Subject: Application 3/2021/0121 (Officer Alex Shutt)

We would be grateful if you could consider the following points regarding the application for tree work by Co-op Estates on Land North of Barley Close Whalley, application number 3/2021/0121.

Figure 2: BS5837:2012 Default specification for protective barrier

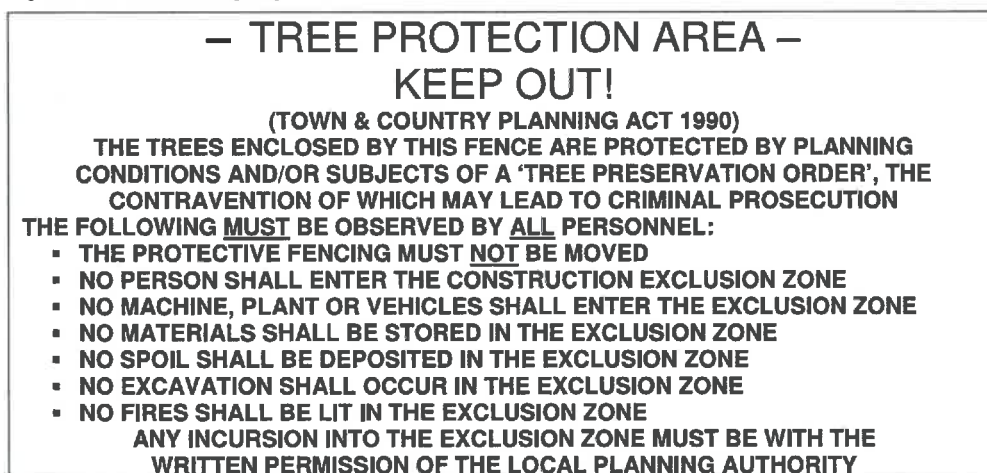
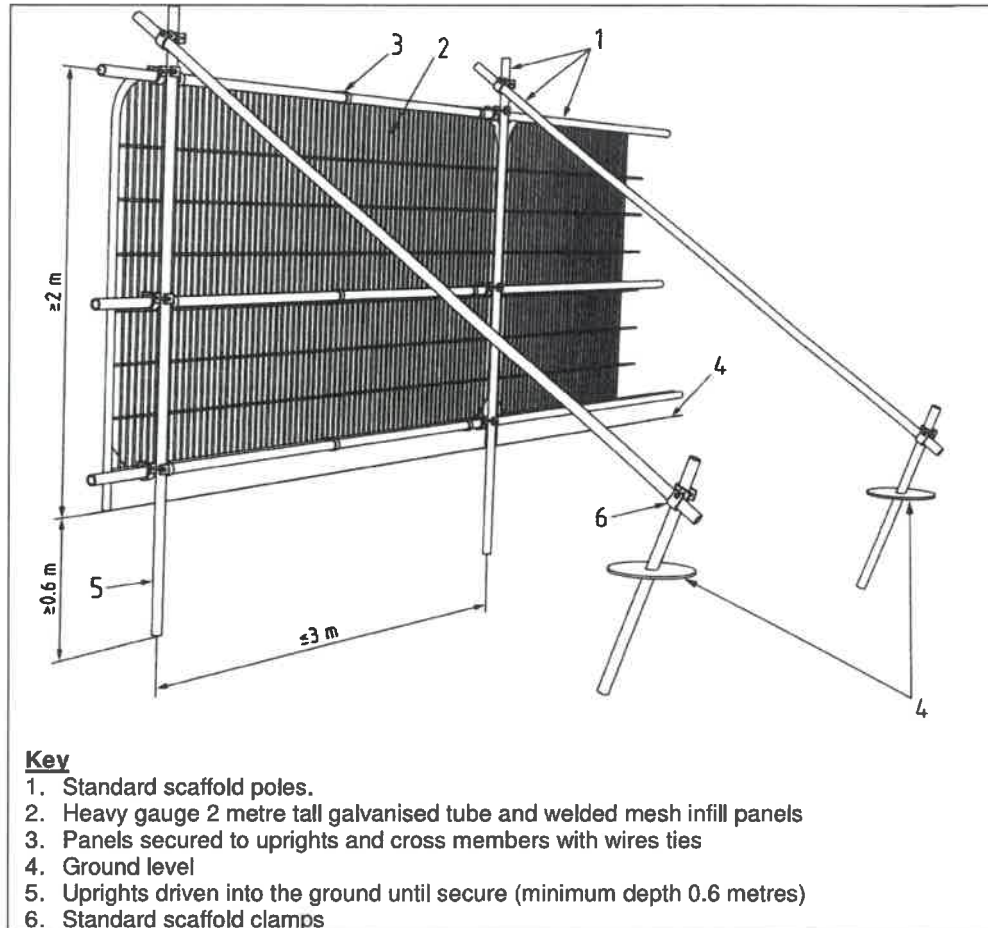
4. Where is the proposed fencing going to erected, and for what time-line?
5. There are several statements in the Arboricultural Impact Assessment document from the agent that state 'From the information provided by the client to date....'. This statement creates alarm bells that the client may have further plans for this land. What safeguard is there, that once the trees have been removed, the land remains grassland?
